**Re: Planning Application 20/1103**

**Address: Overdale York Lane Langho BB6 8DT**

**Description: Proposed replacement dwelling.**

Proposed Ground Floor Plan

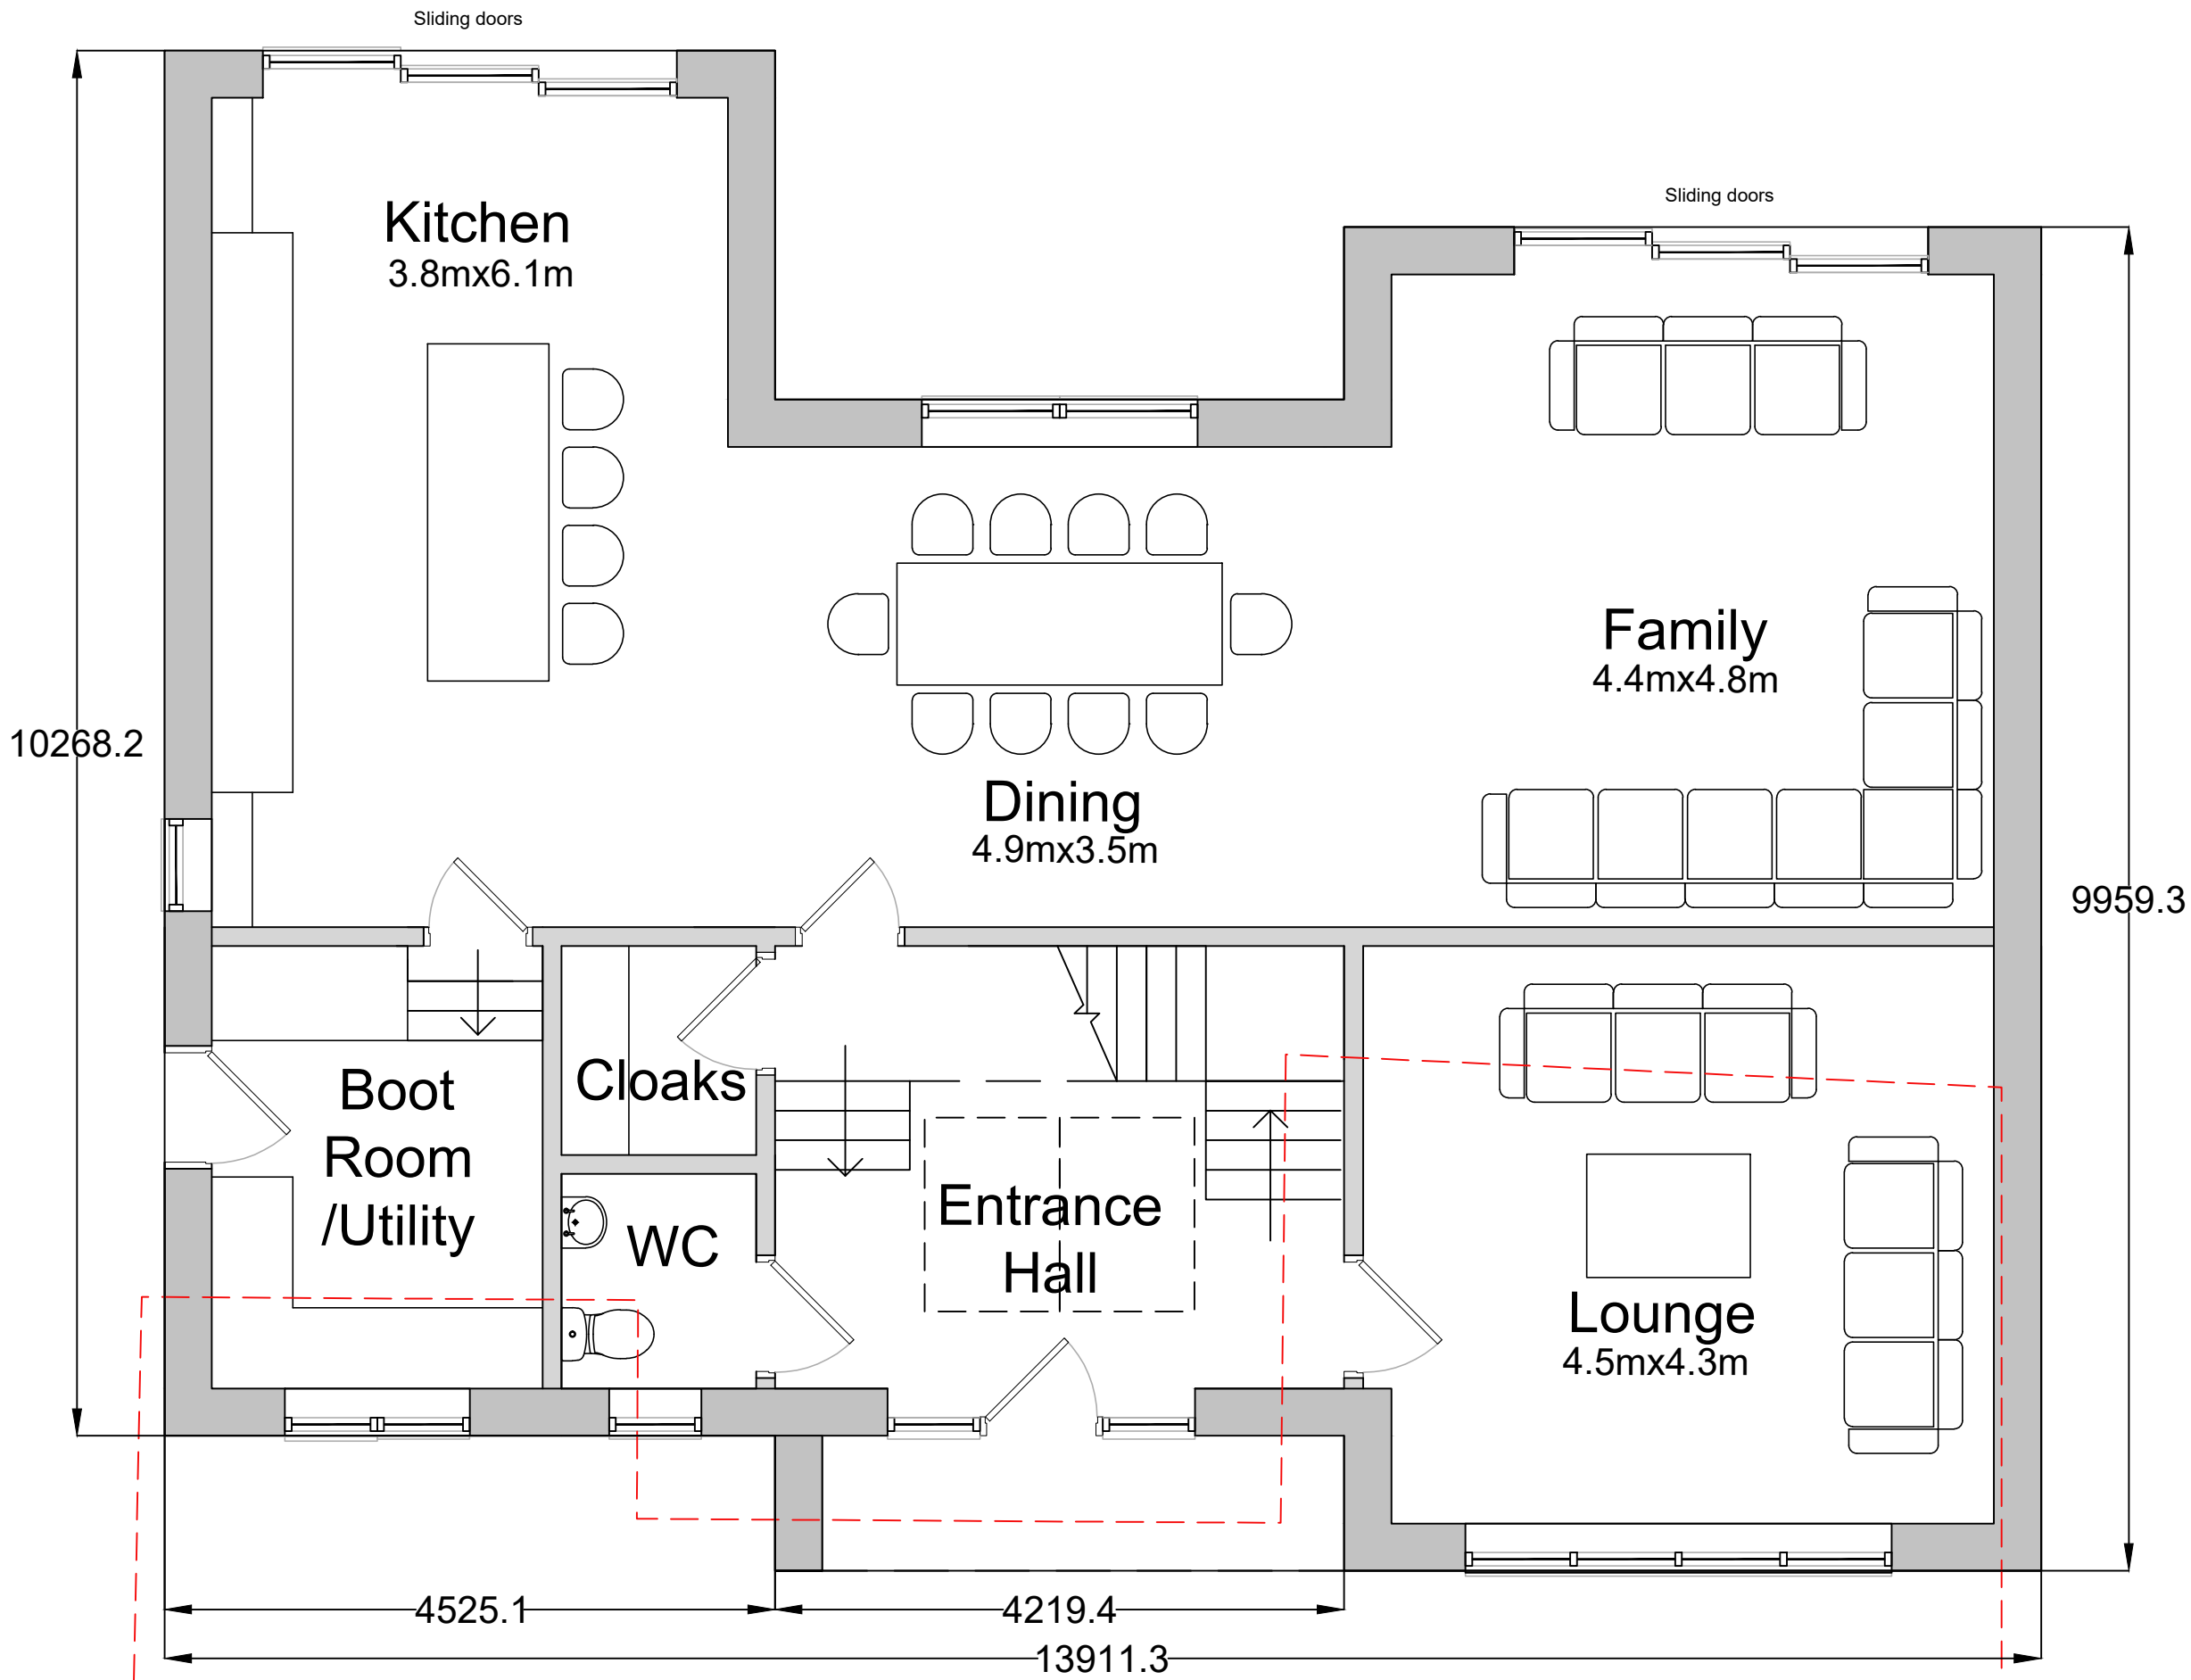
With respect to this application we would not raise any objections to the principle of the application. However there is a concern regarding the off street parking.

Lancashire's Parking Standards would indicate that the 4 bedoomed replacement dwelling should have 3 off-street parking spaces. Additionally, as York Lane is a classified road it is also expected that the vehicles are able to enter and exit the driveway in a forward gear.

In order to progress the application we would look for further submissions showing how our concerns can be allayed
